**Rezoning Transportation Analysis**  
**Petition Number: Insert Zoning Petition #2021-270**  
*General Location Identifier: 10502126, 10502127*

**Revision Log:**

Date	Description
04-12-2022	First Review (AO)
05-25-2022	Second Review (AO)
06-29-2022	Third Review (AO)

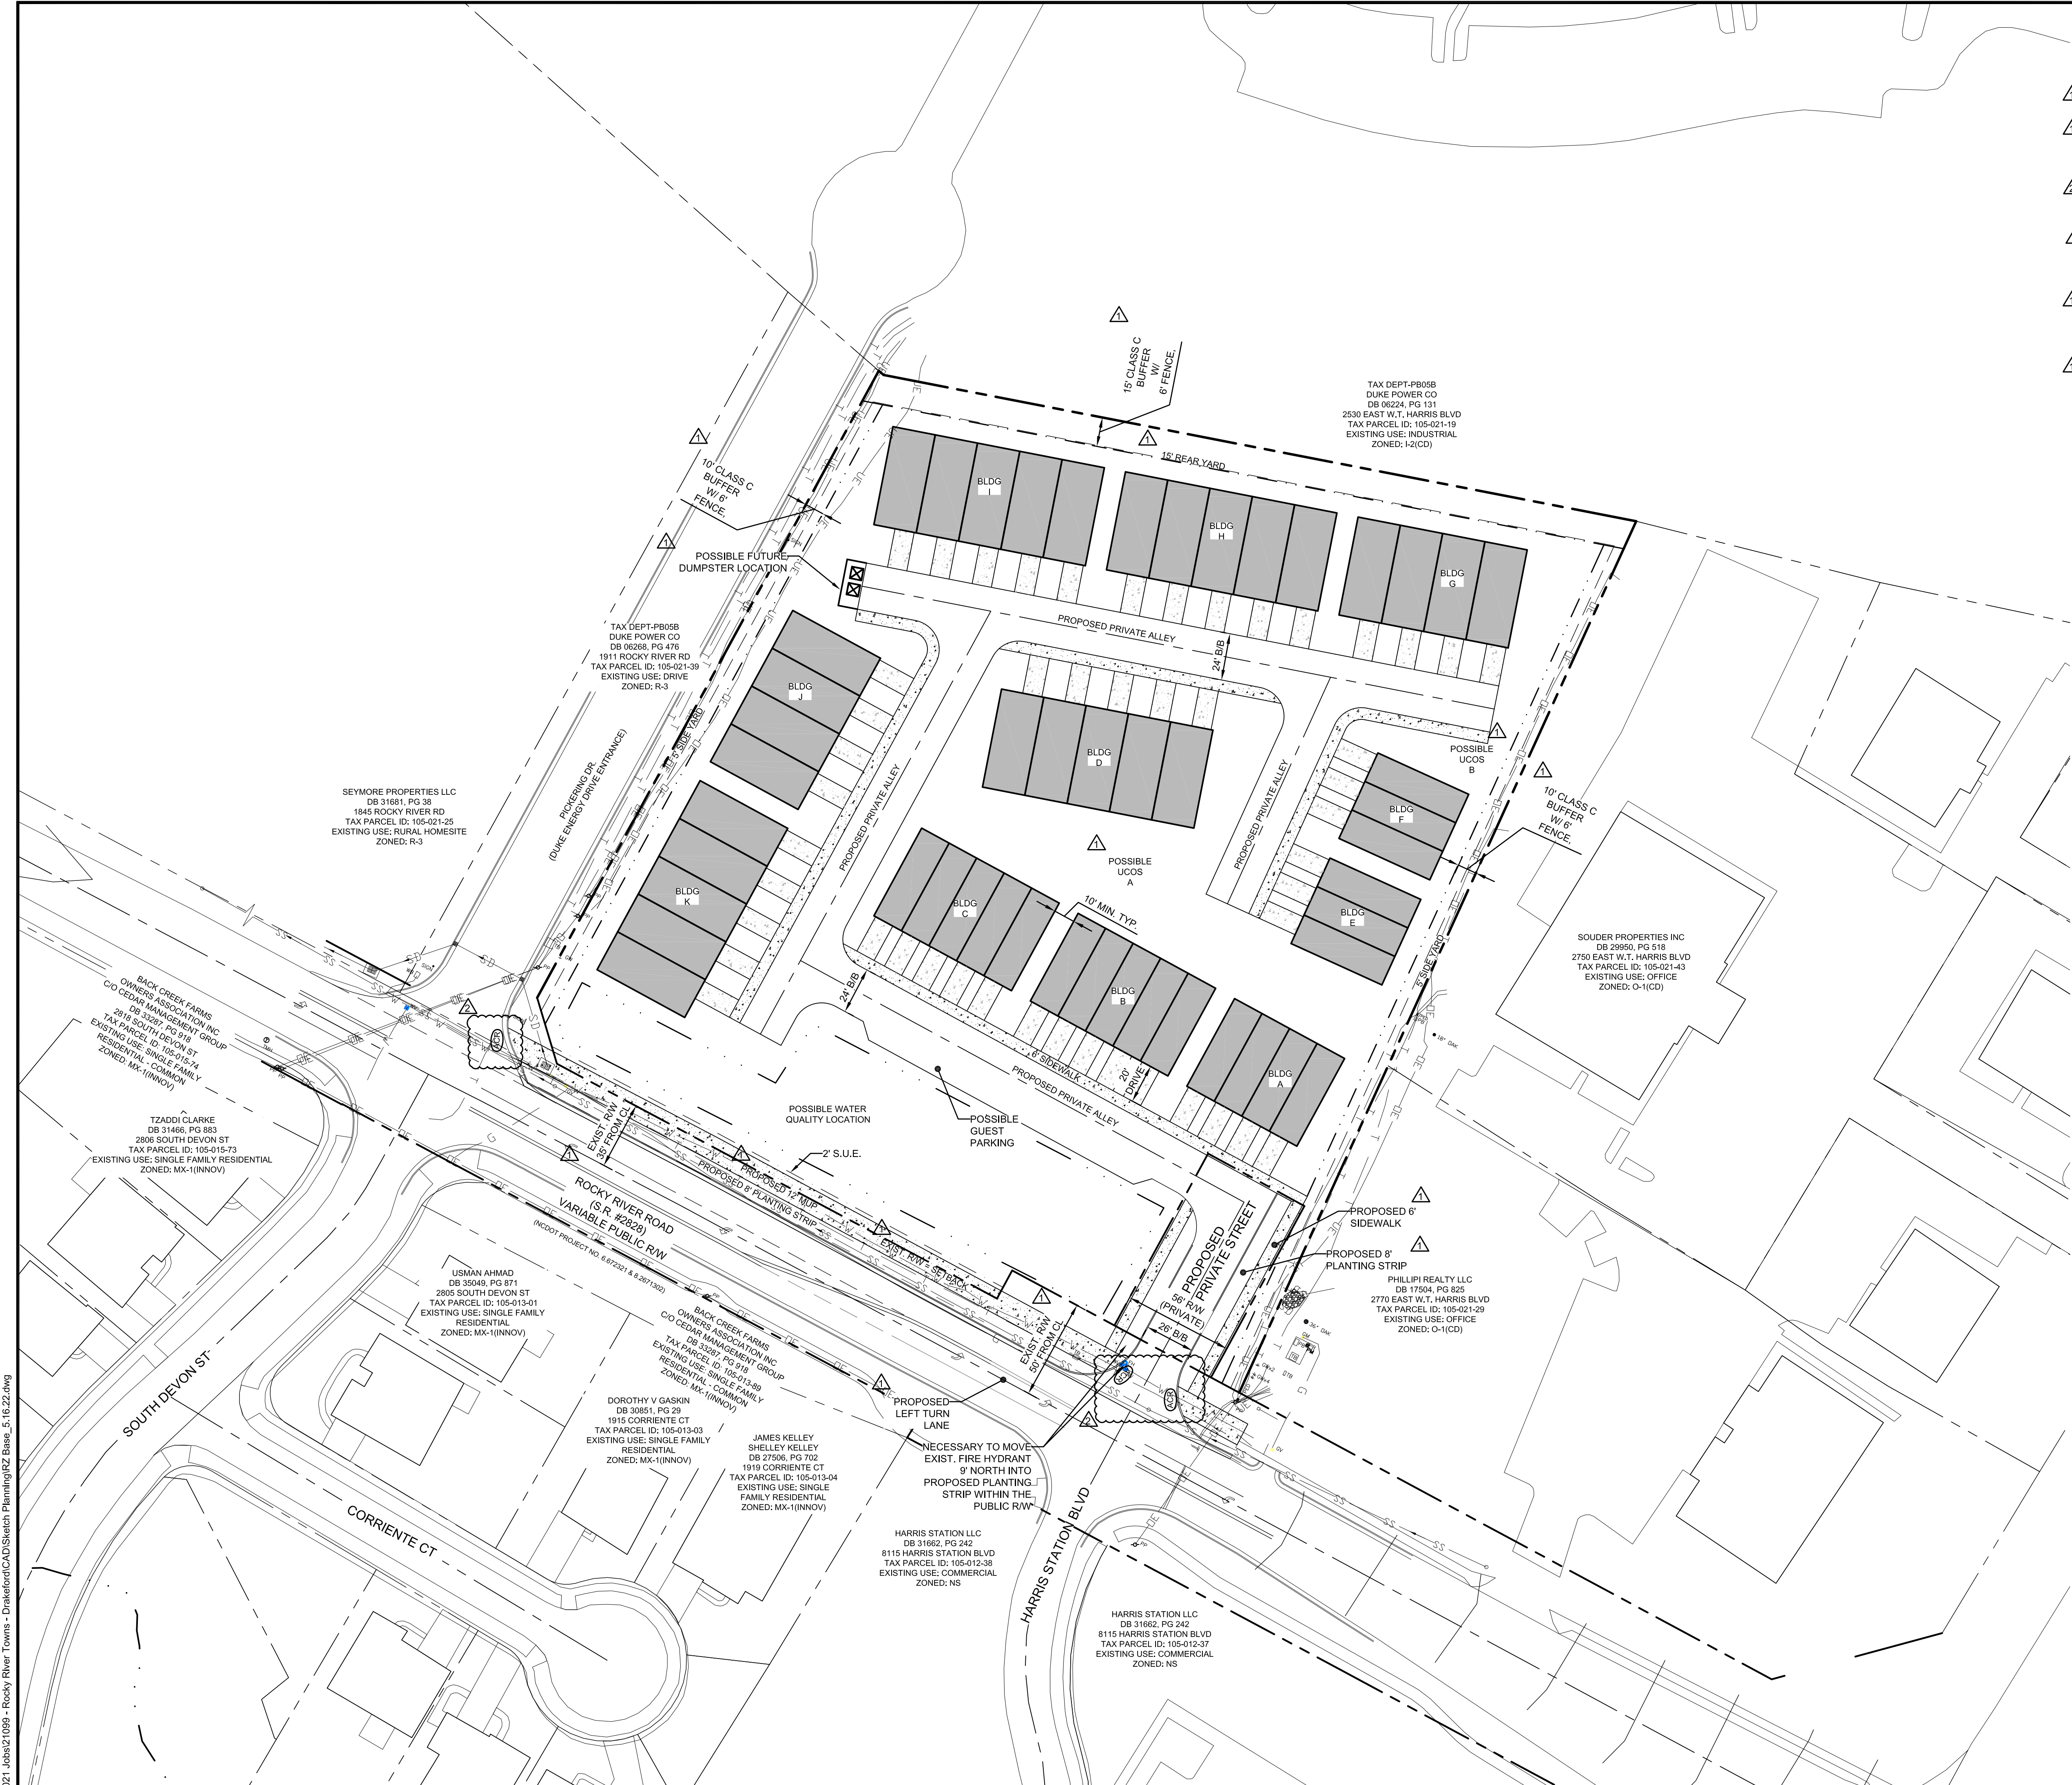
1. **Outstanding Comment from 04-12-2022:**

**Curbline:**

- a. **Rocky River Road:** Distance from centerline to back of curb: 19 feet

Label and dimension the curb and gutter from the centerline for each road on the site plan.

- 11. **Update to Comment (New Site Plan, 6-28-2022):** ~~Revise site plan and conditional note(s) to commit to relocating existing storm drainage infrastructure to location to be determined during permitting. Revise site plan removing existing storm drainage from site plan that is currently showing it in the proposed multi-use path.~~
